March 29, 2010

**Re: Minor Site Plan Review: 231 York Street; Demolition of existing building and construction of new building for restaurant use**

**Site Plan Application # 09-79900017**  
**CBL: 044-E-003-001**

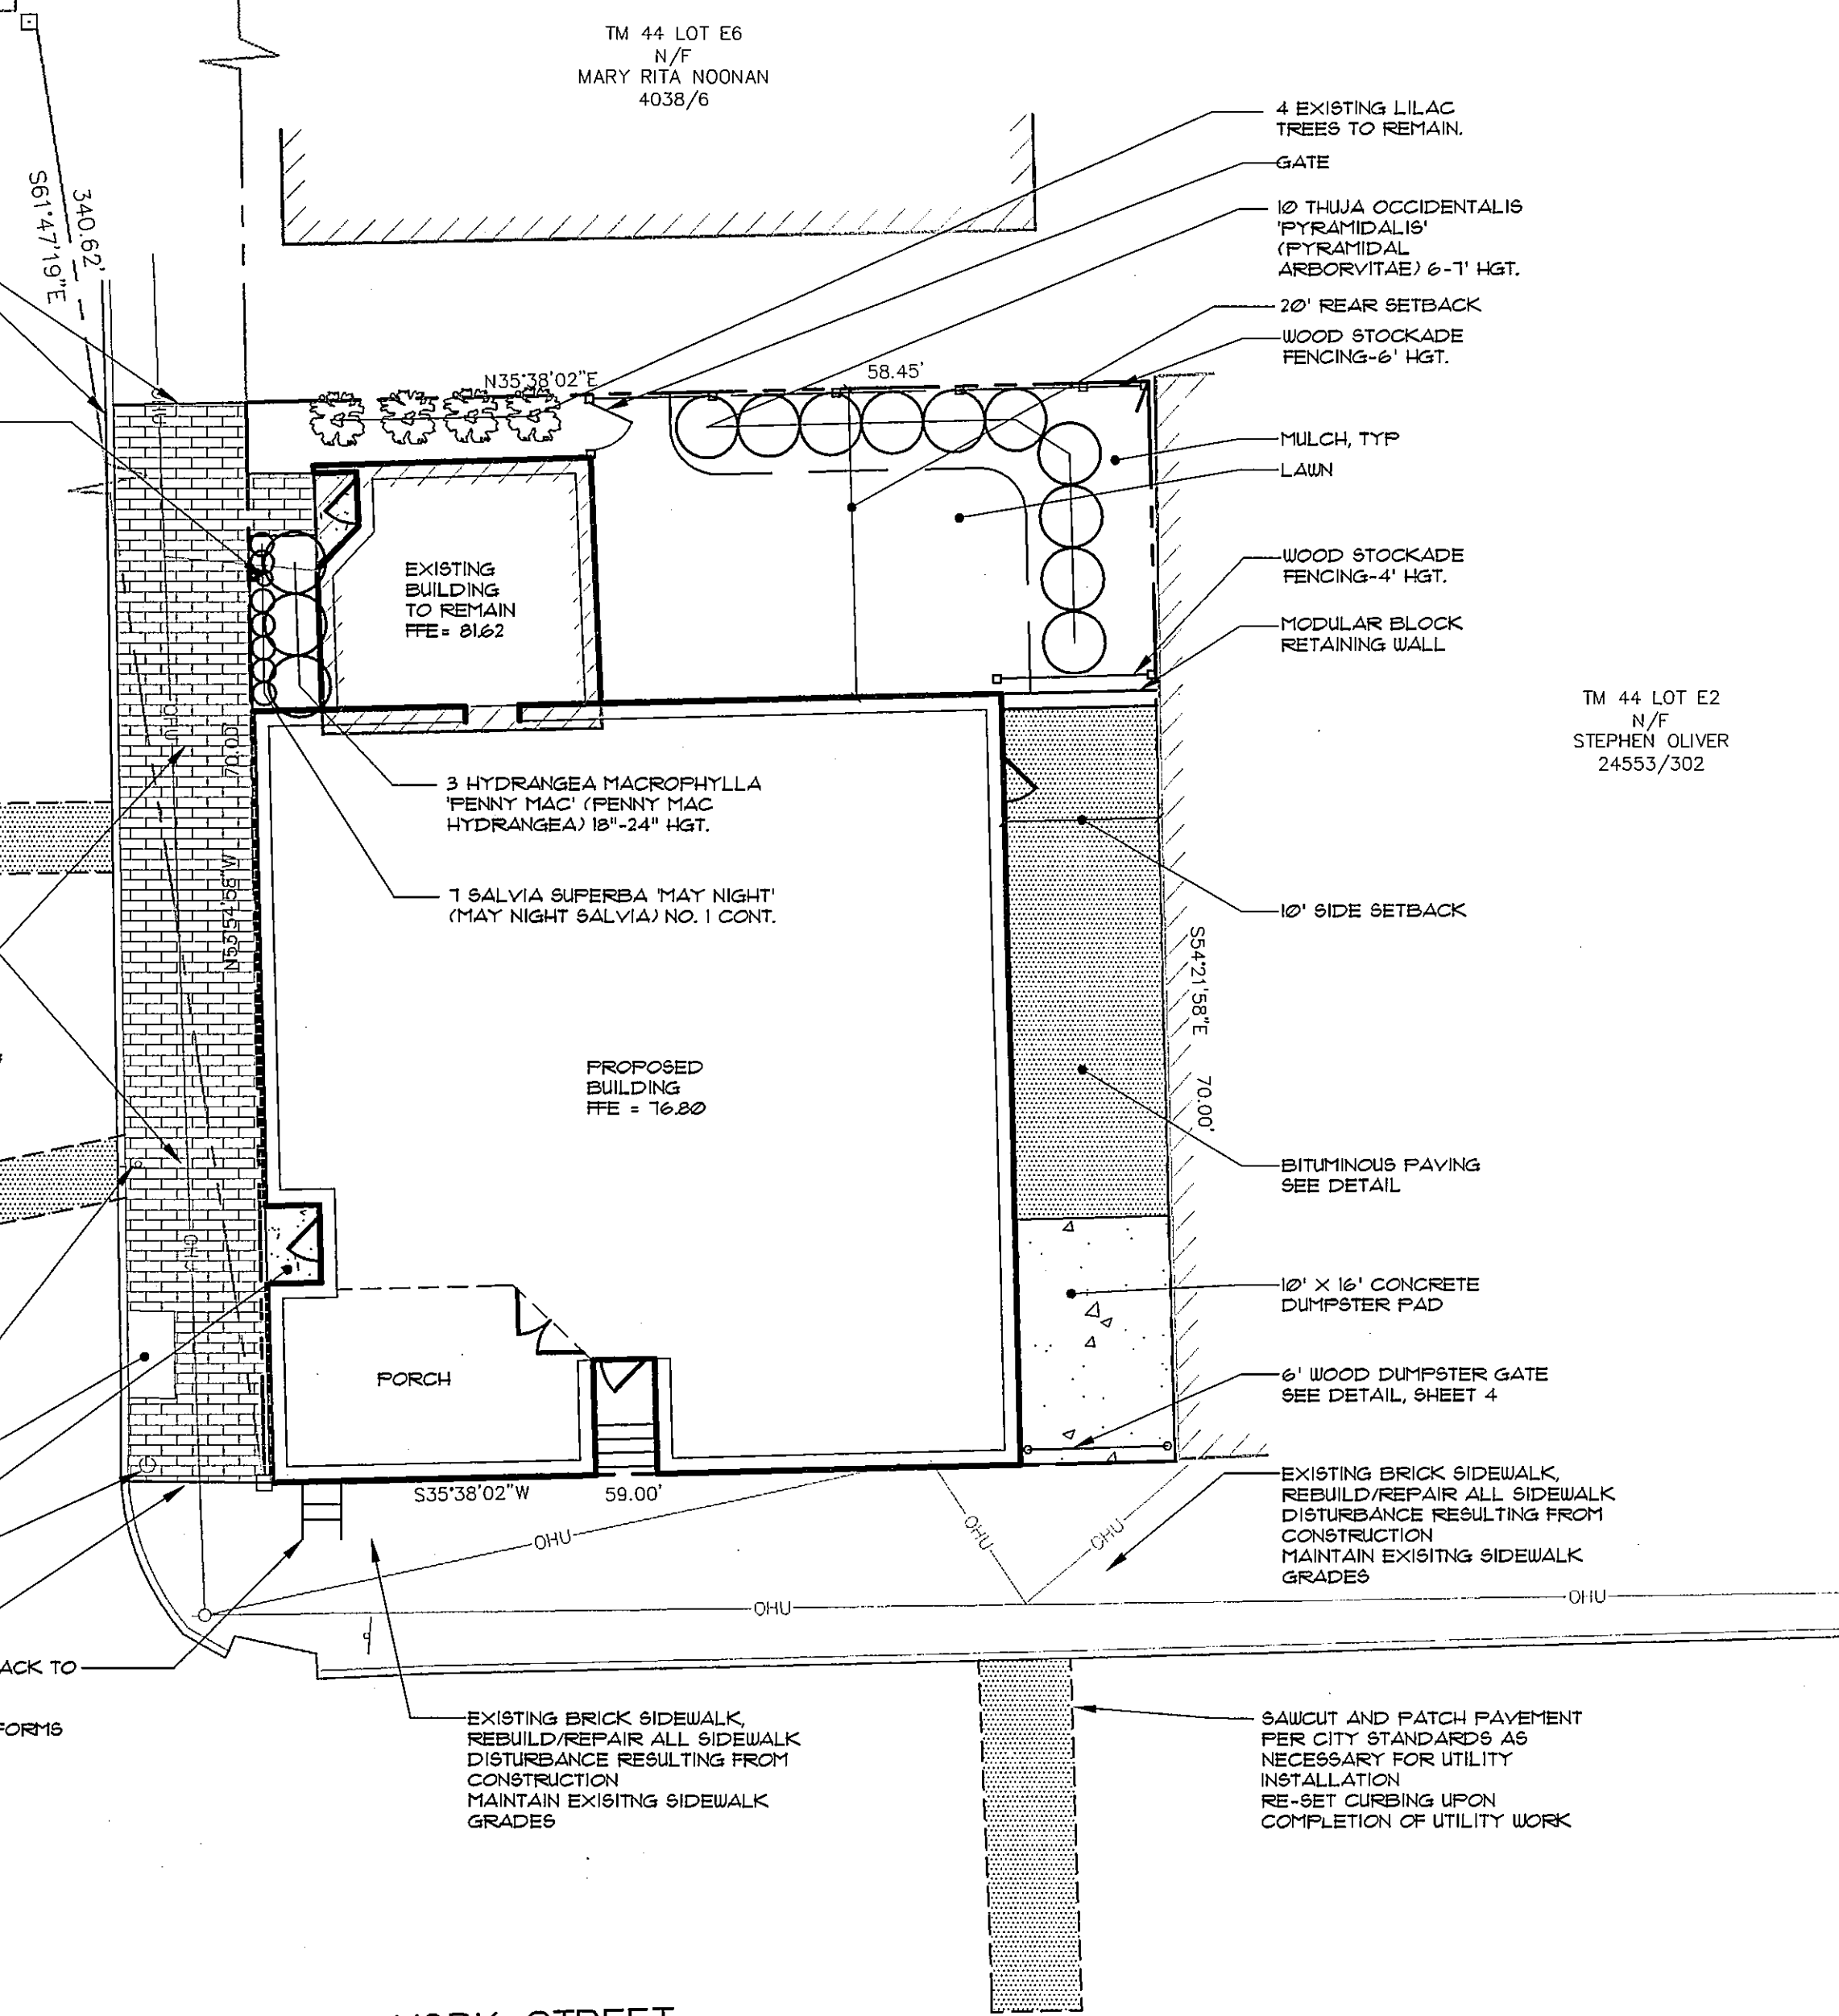
**a) The 'backyard' area** - preserves the existing lilac shrubs and proposes the planting of 10 Arborvitae as a screen. Selecting 'Techney' Arborvitae as a cultivar which is slow-growing and range to a height of 10-15' vs. the 20-30' height for the 'Pyramidalis' might work best for this site.

**b) Sideyard area on York Street** - Additional screening between the proposed project and the adjacent property near the dumpster pad might be achieved by narrowing up the pavement and adding landscape treatment and or fencing. Creating a 4' wide 'green-space' could greatly improve this area. There could be a wide array of plants that could fit into the site without overwhelming it.

**c) Street-trees** - The project calls out for one street tree on Brackett Street, this is consistent with our earlier discussions. York Street frontage could have a 'tree option', in the past an open view was desired and the Harbor View Memorial Park across the street was the landscape focus. Recent tree planting nearby on York Street at Tate Street have added nicely into the street-scape without effecting harbor views. Adding one or two street-trees on York Street would be an 'option' if the project had interest in this effort.
